State of Washington
DEPARTMENT OF FISH AND WILDLIFE

November 25, 2024

SUBJECT: WDFW COMMENTS ON SP-24-00014 MLH SHORT PLAT

**Critical Areas Map**

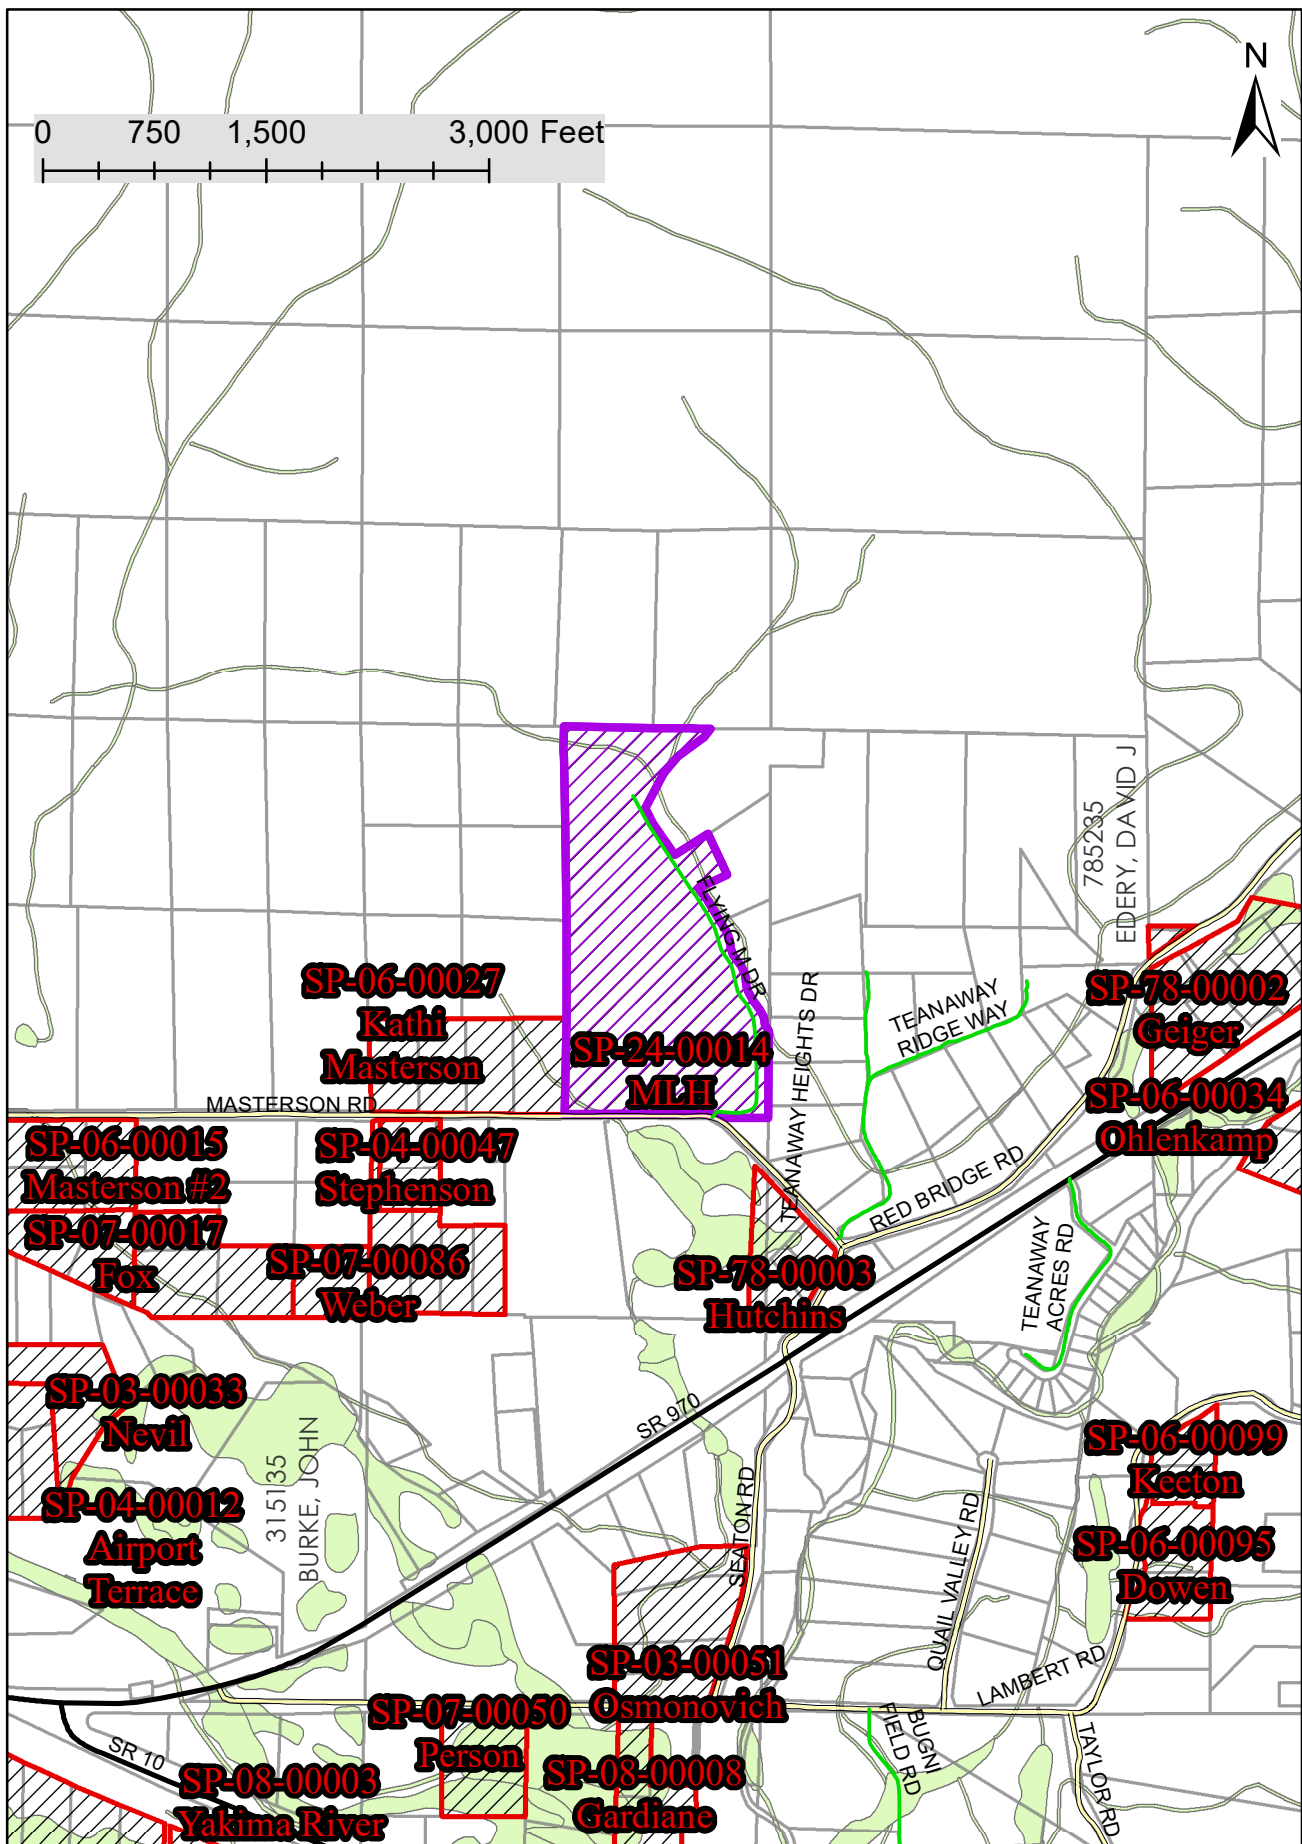
We understand that this proposal is a short plat, and no development actions are currently proposed. While no critical areas report is provided with the application materials, there are critical areas present on the subject parcels, including Fish and Wildlife Habitat Conservation Areas (FWHCA). Prior to new parcels being created as part of this project, the applicants should clearly demonstrate that they are not creating lots that will require variances and/or reasonable use exceptions from the critical areas requirements or other relevant sections of code when development is proposed.

There is an unnamed tributary that has previously been captured by the old Masterson Ditch. This watercourse appears to continue through the parcel and irrigated land in a straightened ditch like feature, before crossing Masterson Road and eventually enters the Teanaway River. This watercourse should be acknowledged and shown in the plans to ensure appropriate riparian management zones are applied to future land uses. This project area is also in a known elk winter range area.

- Prior to approval of this application, complete a critical areas report that identifies all critical areas present within the project area and the required setbacks. Completing this report and assessment will result in the identification of areas where development would be allowed without the need for variances or reasonable use exceptions.

- If a critical areas report is not completed prior to approval, we recommend identifying the water course and the development envelope outside of critical areas and their setbacks to ensure future development will protect the unnamed stream.
